**FROM: Katie Kurek TO: Arun District Council
FAO: S Davis**

SUBJECT: AL/72/17/PL - 2 No. dwellings. This application is a Departure of the Development Plan.

Land West Of, Fontwell Avenue, Eastergate, West Sussex, PO20 3RU

TITLE
PROPOSED SITE PLAN
PLOTS 1 & 2

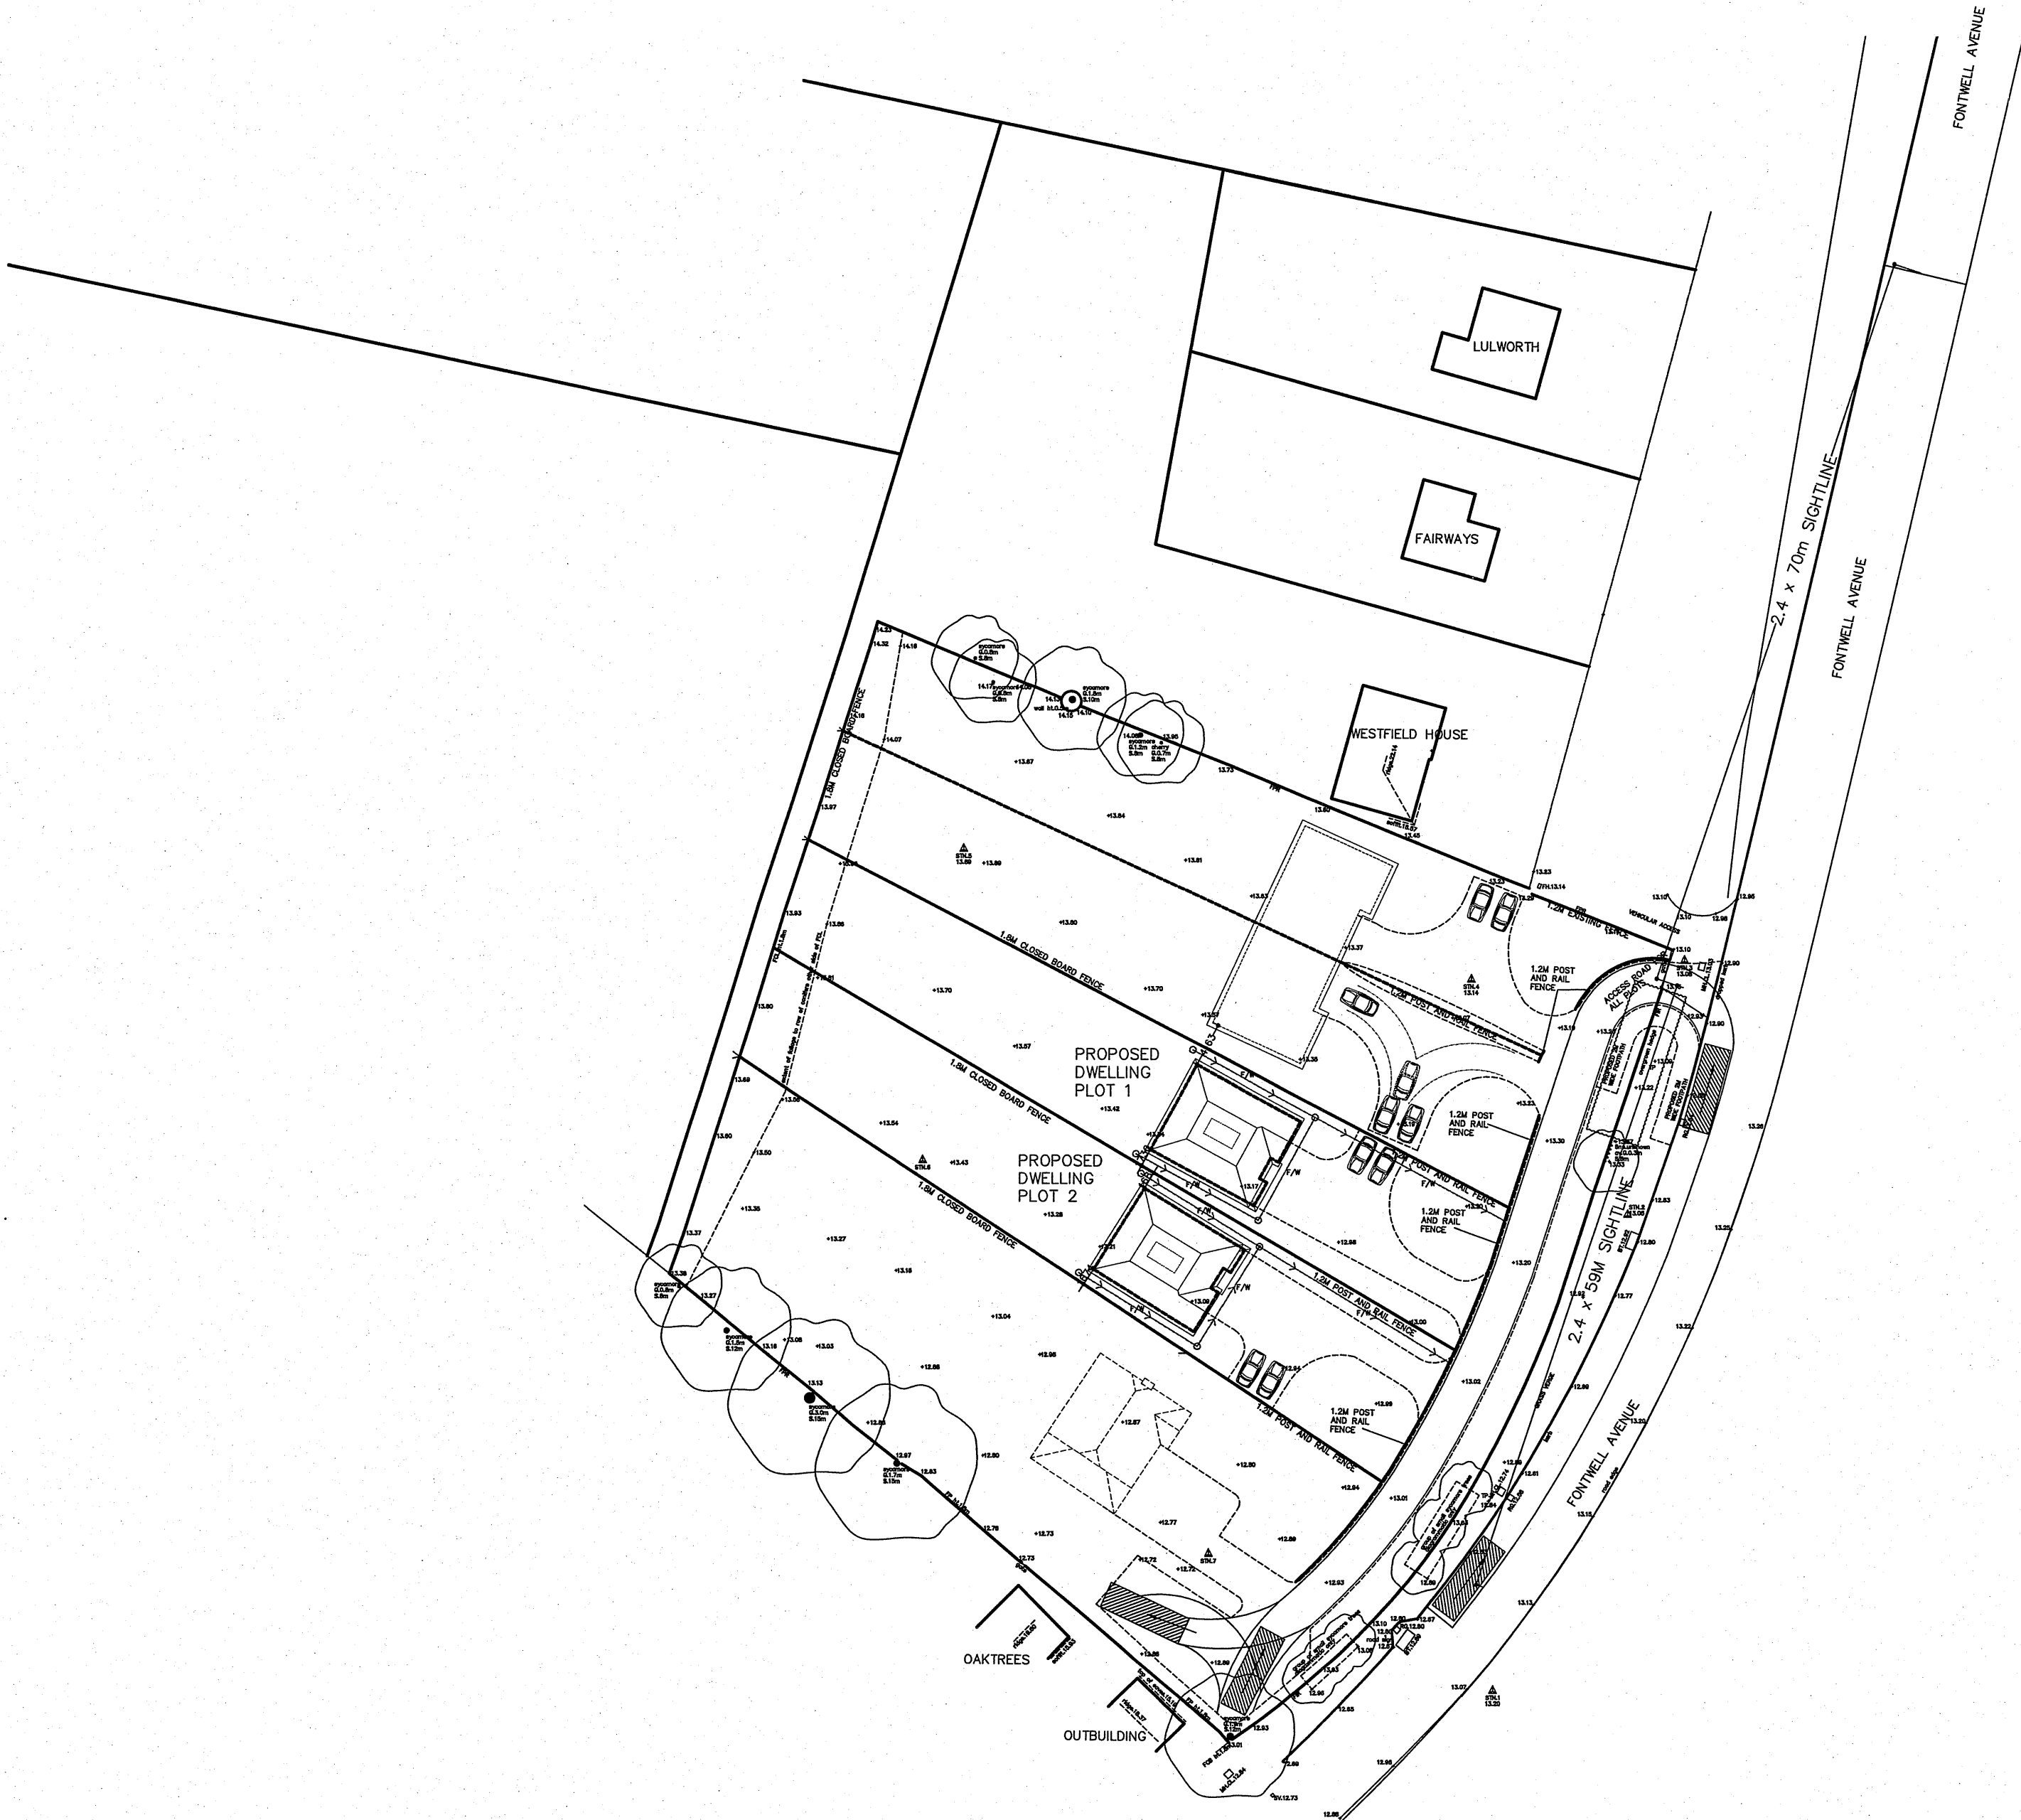
This current application seeks 2 x detached dwellings on plot 2 (middle plot) in place of approved single dwelling. No changes to existing approved access arrangements. The previously approved vehicle visibility splays of 2.4m x 70m to the north and 2.4m by 59m to the south have been demonstrated. These should be conditioned and maintained in perpetuity.

On the basis that two allocated car parking spaces per dwelling have been provided the WSCC Car Parking Demand Calculator envisions a total demand for 3 spaces per dwelling. From an inspection of the proposed plans there is sufficient space to accommodate further visitor parking and still enable a turn on site to exit on to the publically maintained highway (Fontwell Avenue) in a forward gear.

We remind the LPA of previous conditions regards access, visibility, parking, turning, bicycle storage and Construction Management Plan that would be required as part of these proposals also. The previous informative regards technical approval for works in the public highway should also be noted (please refer to most recent highways conditions advised under AL/121/16).
